16 December 2013

Department of Planning and Infrastructure

**Sydney CBD and South East Light Rail Project – Australian Football League (AFL) submission**

Tramway Oval Baseline - Construction

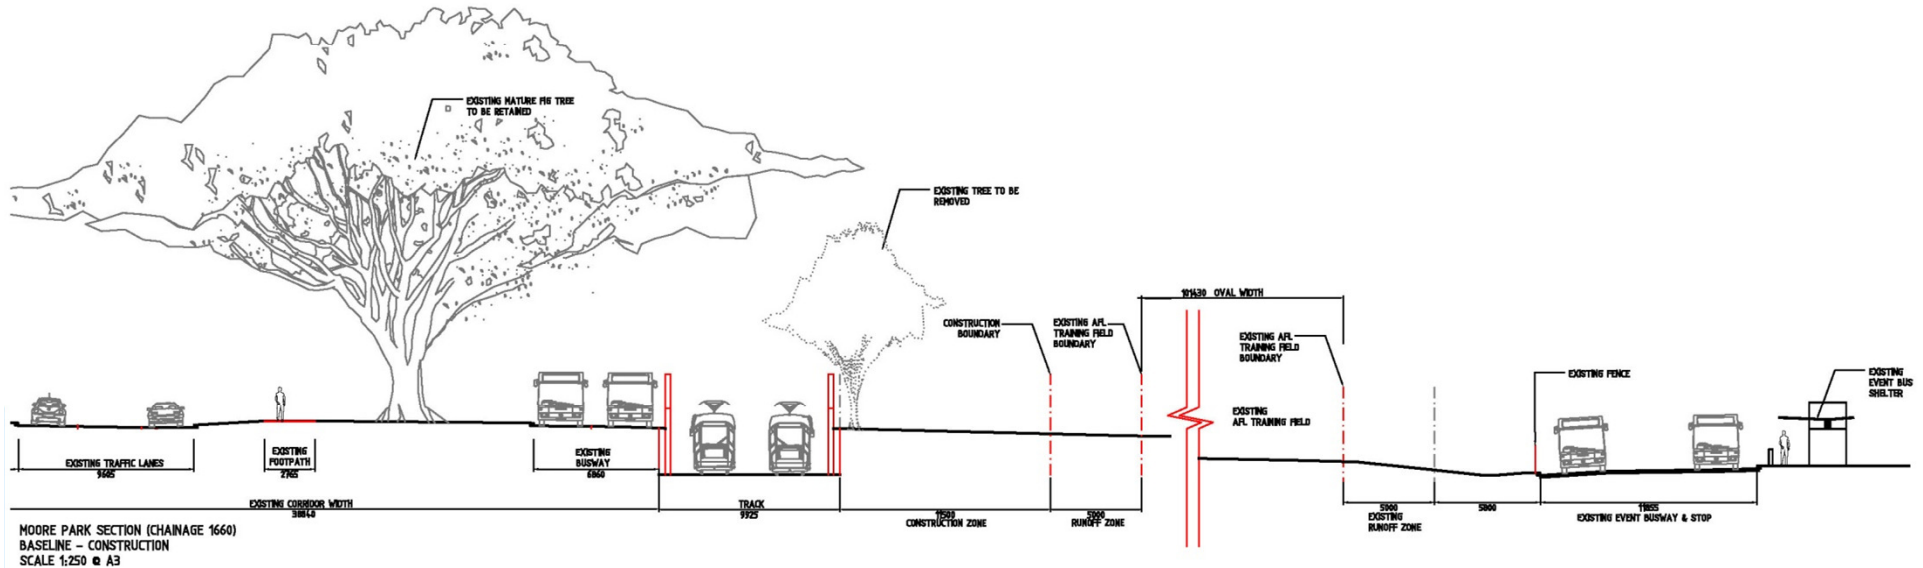
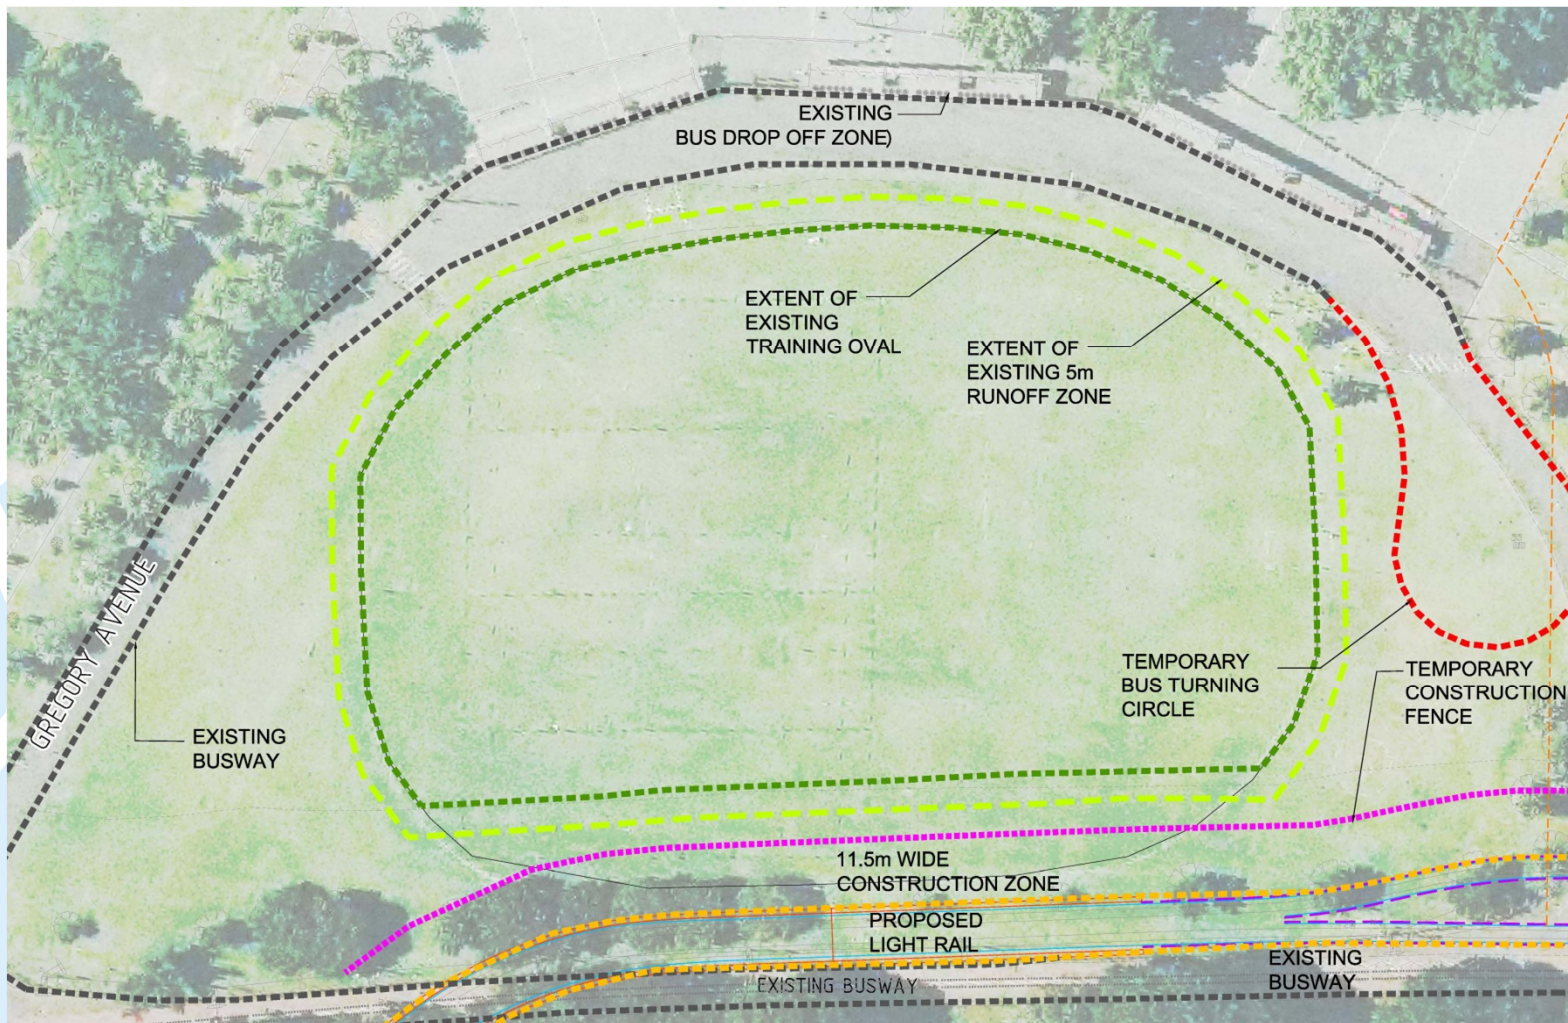
The AFL recommends avoiding any loss of training oval width during construction, and cannot accept any reduction in the width of Tramway Oval post construction.

- The AFL cannot accept the width of Tramway Oval being impacted by 13 metres during construction, with a reduced SSL training width remaining post construction.
- The AFL does not support the Bus Loop Event service road remaining as a daily Bus road post construction. This would isolate Tramway Oval inside a transport hub and significantly impact accessing the field and user safety during SSL training and other uses.
- The AFL would support extending the Oval to the east pre commencement of the CSELR Project in order to limit the construction zone footprint on the western boundary. The impact of a reduced training width (projected 7m) during peak construction would be offset by a slight increase in overall field width post construction (~4.5m).

Tramway Oval Busway Option-Construction

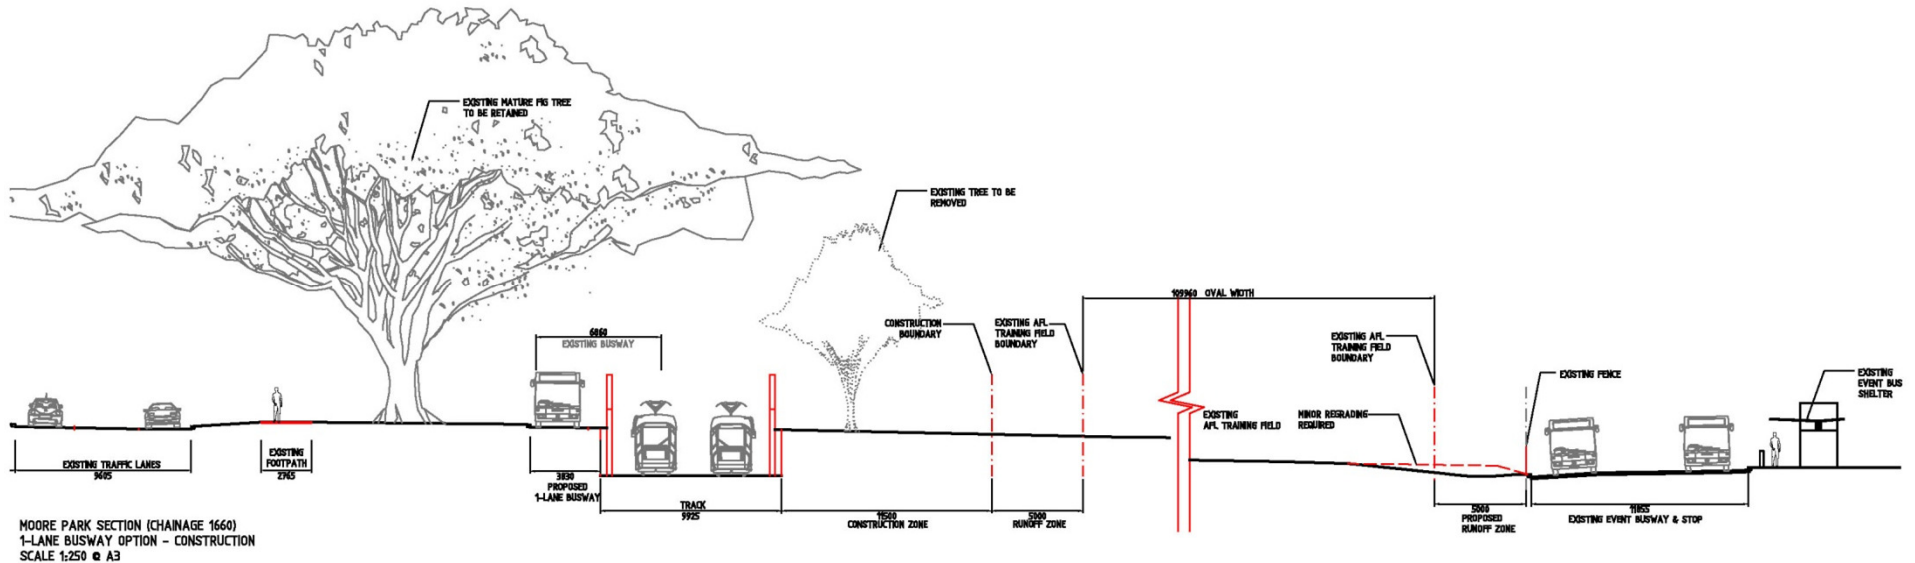
The proposal to utilise the Bus Loop service road (currently event use only) that surrounds Tramway Oval as a daily Bus route throughout construction raises considerable safety concerns.
